CITY OF ALBUQUERQUE

**Re: PRESNow on Coors
Erosion and Sediment Control Plan
CPESC Stamp Date 2-20-19 (F11E019)**

EROSION AND SEDIMENT CONTROL PLAN

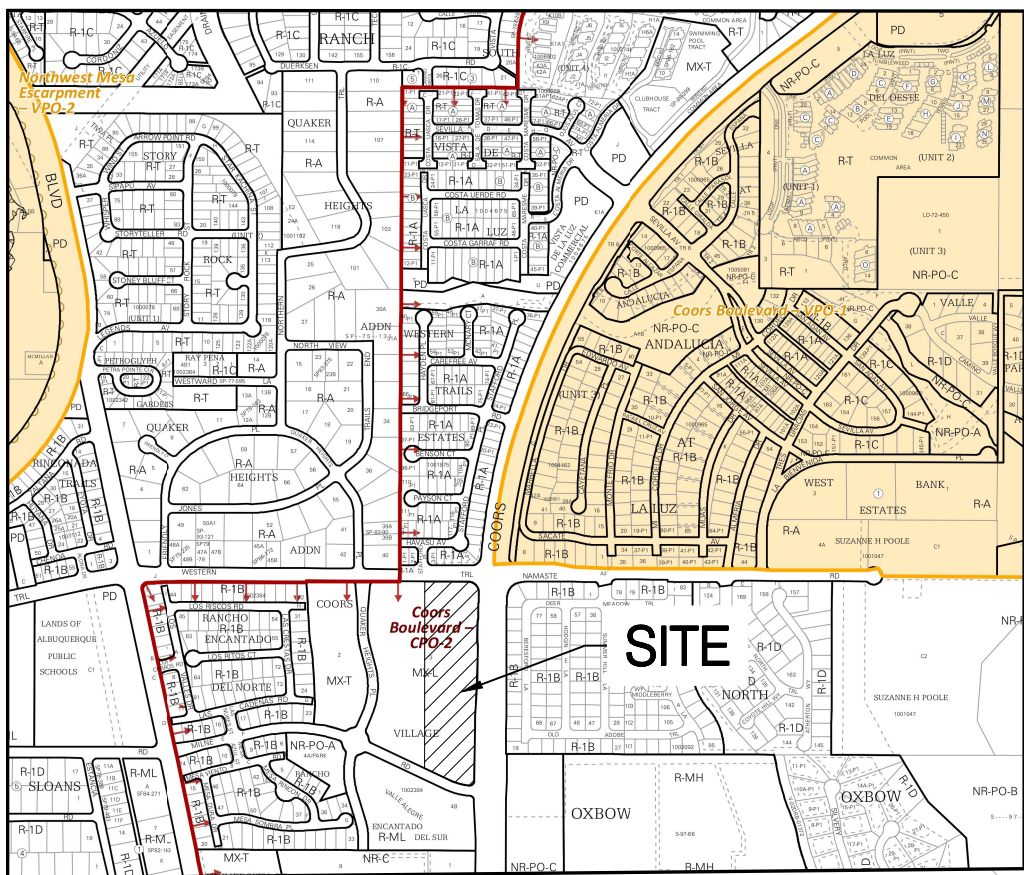
1. The drains for the roof flows will require inlet protection, between the time they are installed to the time they are connected to the drains from the roof.
